Rezoning Transportation Analysis

Petition Number: 2020-080

General Location Identifier: Tax ID 12110110

Date	Description
07-23-2020	First Review (KP)
08-19-2020	Second Review (KP)
08-25-2020	Third Review (LJensen)

RZ1.0

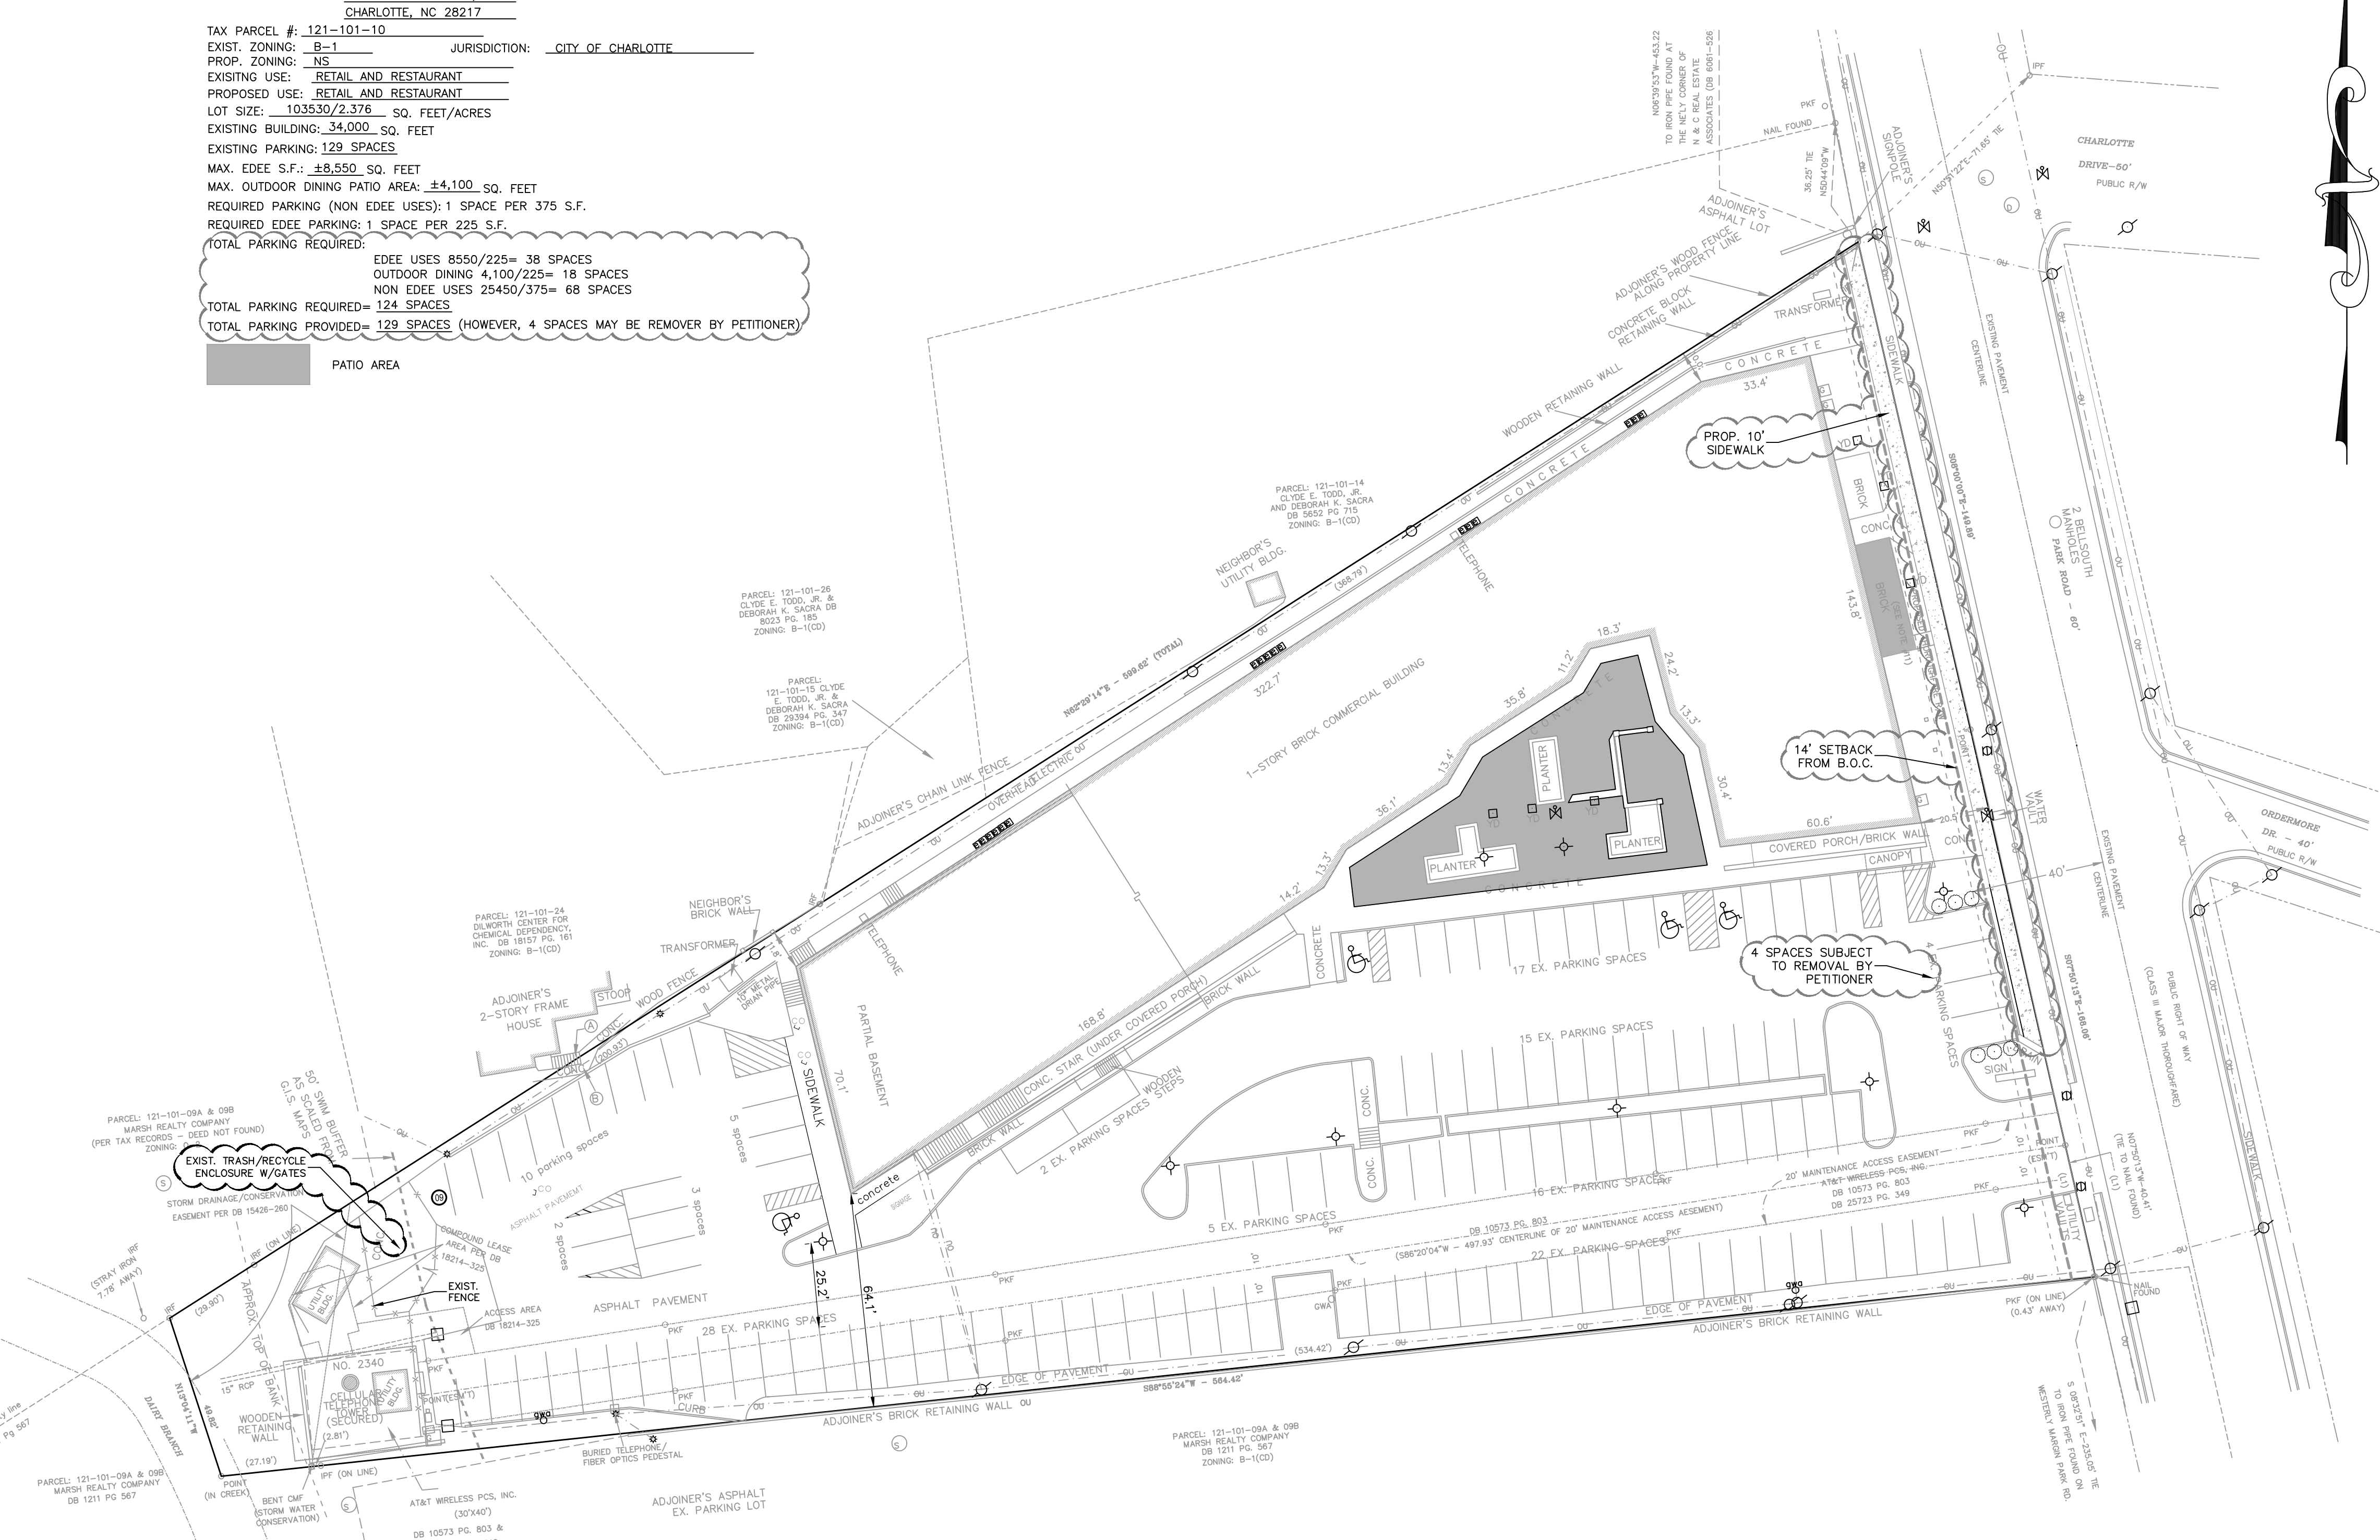
1. ~~Curbline~~ The site plan should show the curb and gutter labeled and dimensioned from the centerline along Park Road.

~~Updated Comment from 08/14/2020 Meeting:~~ Petitioner should revise site plan/conditional notes to widen the existing sidewalk as much as possible along the Park Road frontage. CDOT understands the site's constraints and will continue to work with the petitioner regarding this sidewalk expansion.

~~Comment following resubmittal:~~ The petitioner has agreed to widen the existing sidewalk to 10' along the frontage of Park Road, as depicted in the site plan.
